From: Carol Reynolds <Carol.Reynolds@arun.gov.uk>
Sent: 20 December 2019 11:43
To: Michael Eastham <Michael.Eastham@arun.gov.uk>
Subject: RE: LU/305/19/RES - Parcels A2 and B6 at Hampton Park

Please could I have your consultation responses to the reserved matters application (LU/305/19/RES) on Parcels A2 and B6 at Hampton Park.

Drawing No. 544_PL_CMP B – Phase 3 Construction

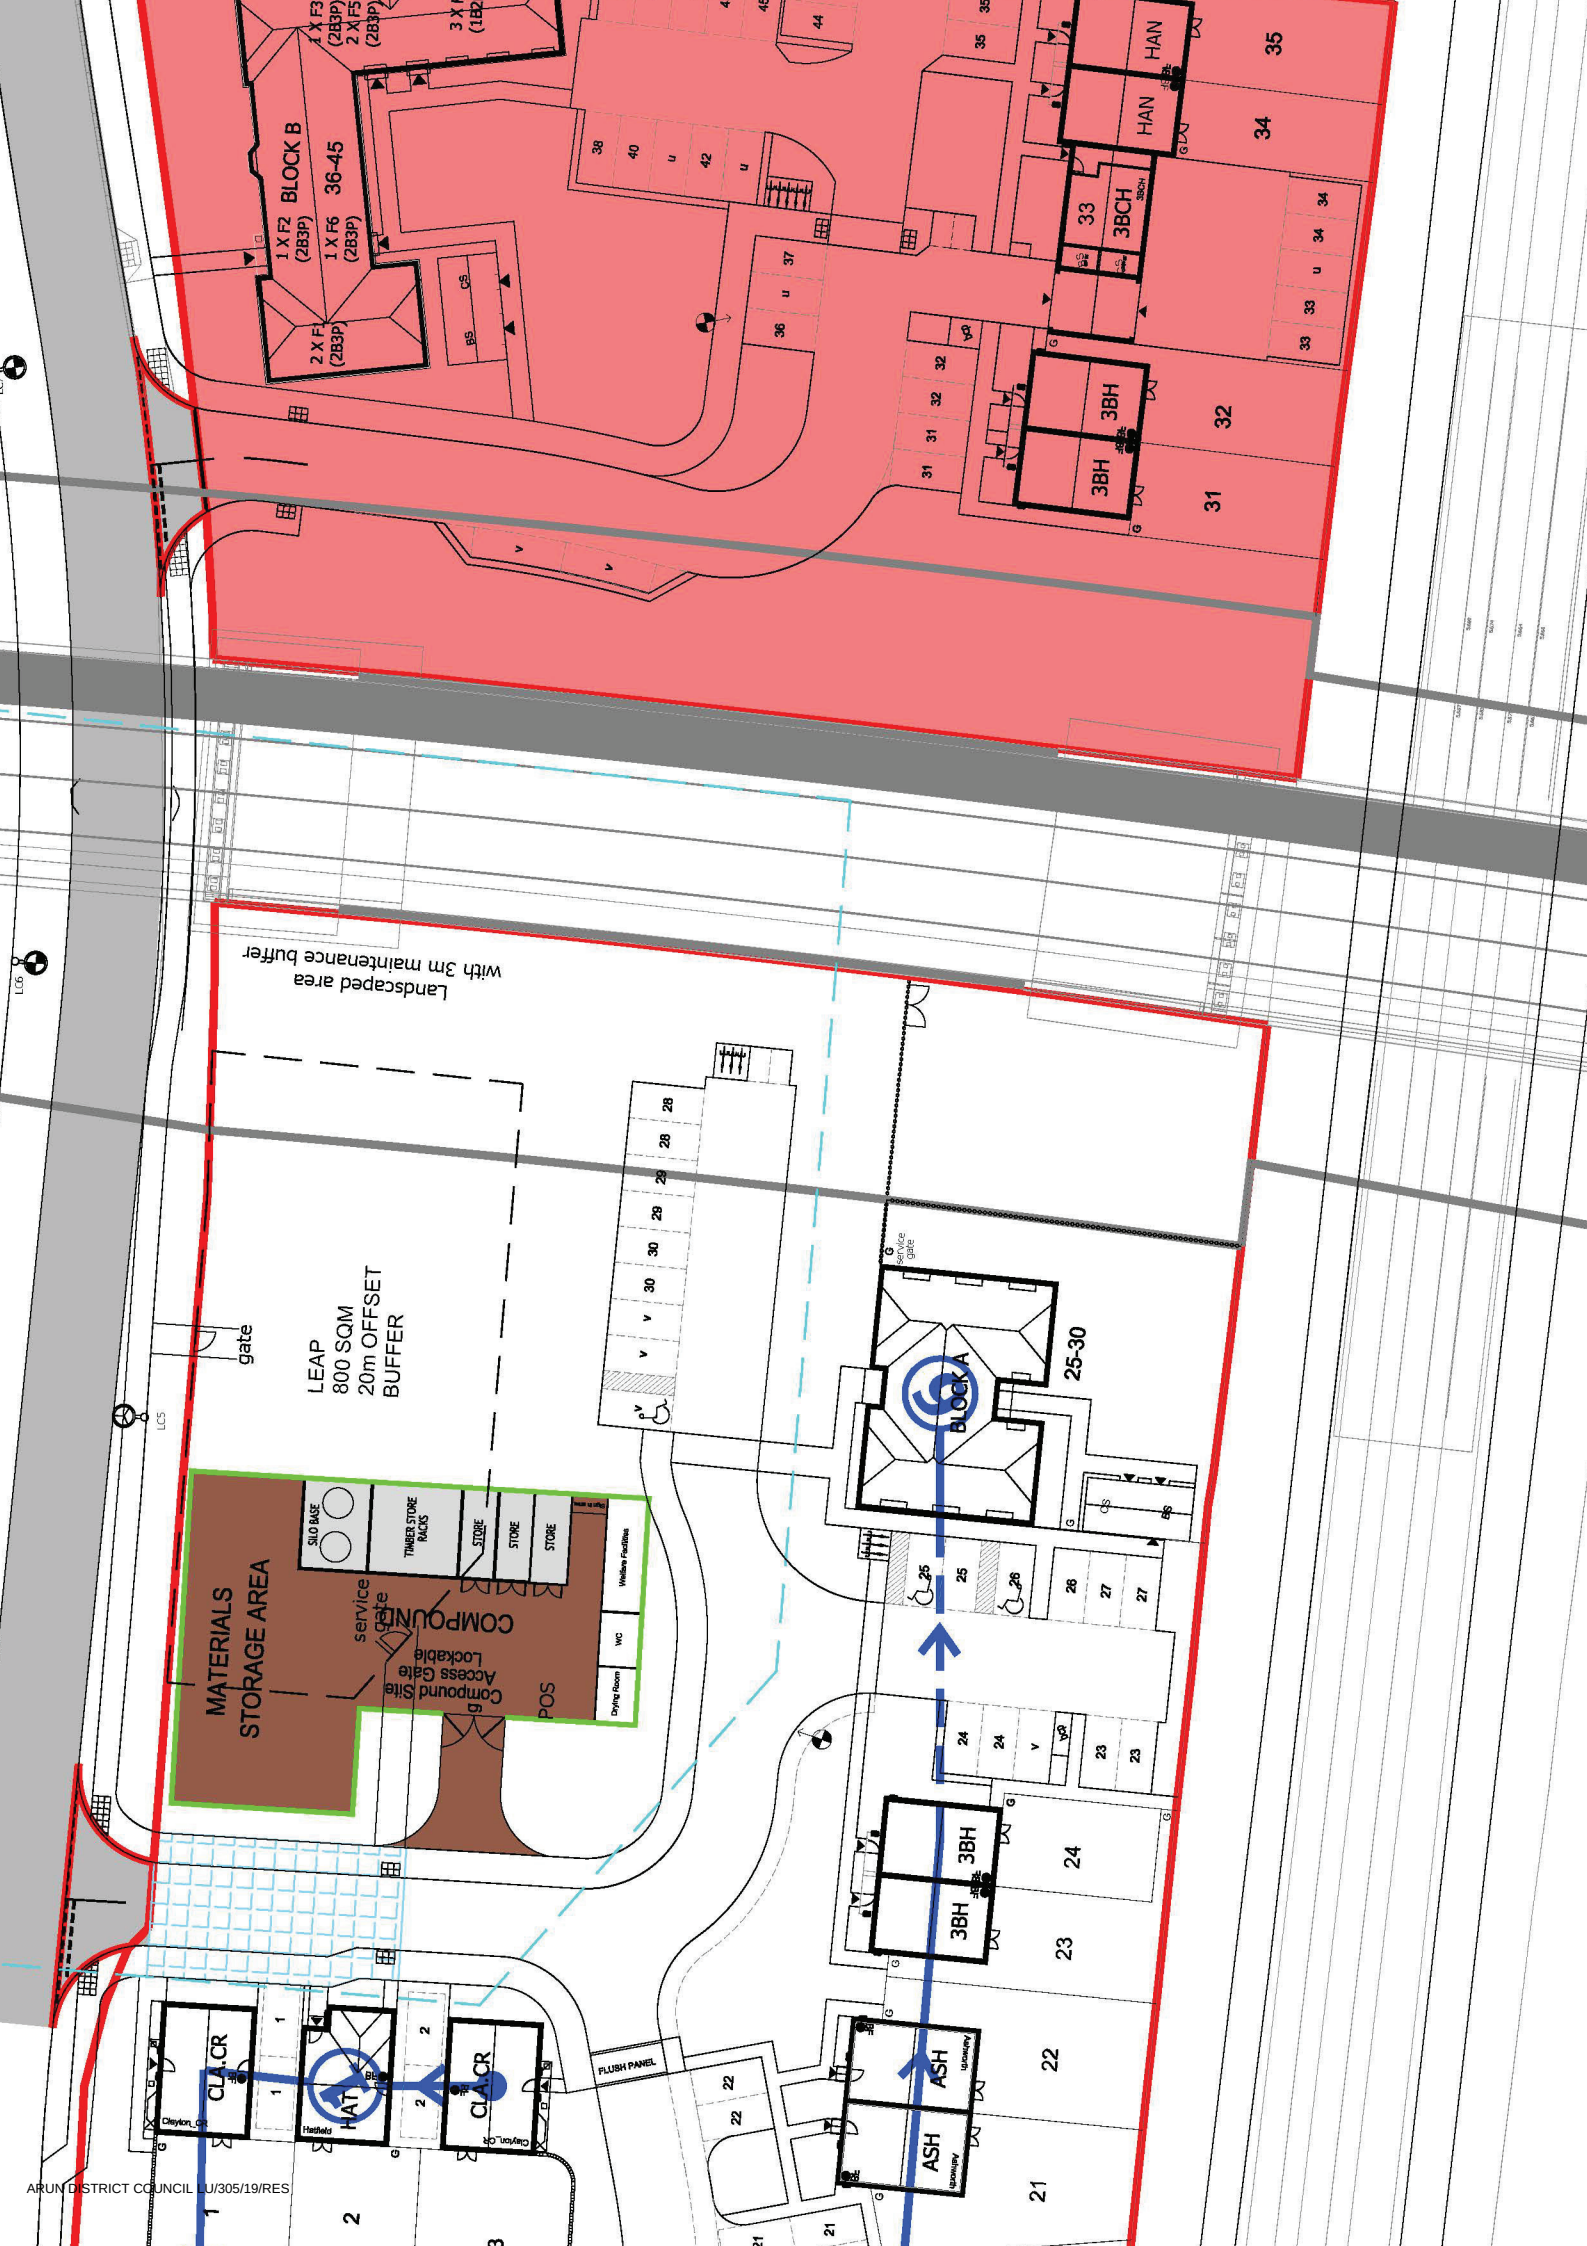
3. Construction Management Plan Review B. 'Area allowed for By Pass.' Please would the applicant provide a suitable buffer zone to be detailed on this plan which aims to protect the amenity of immediately adjacent existing residential units.
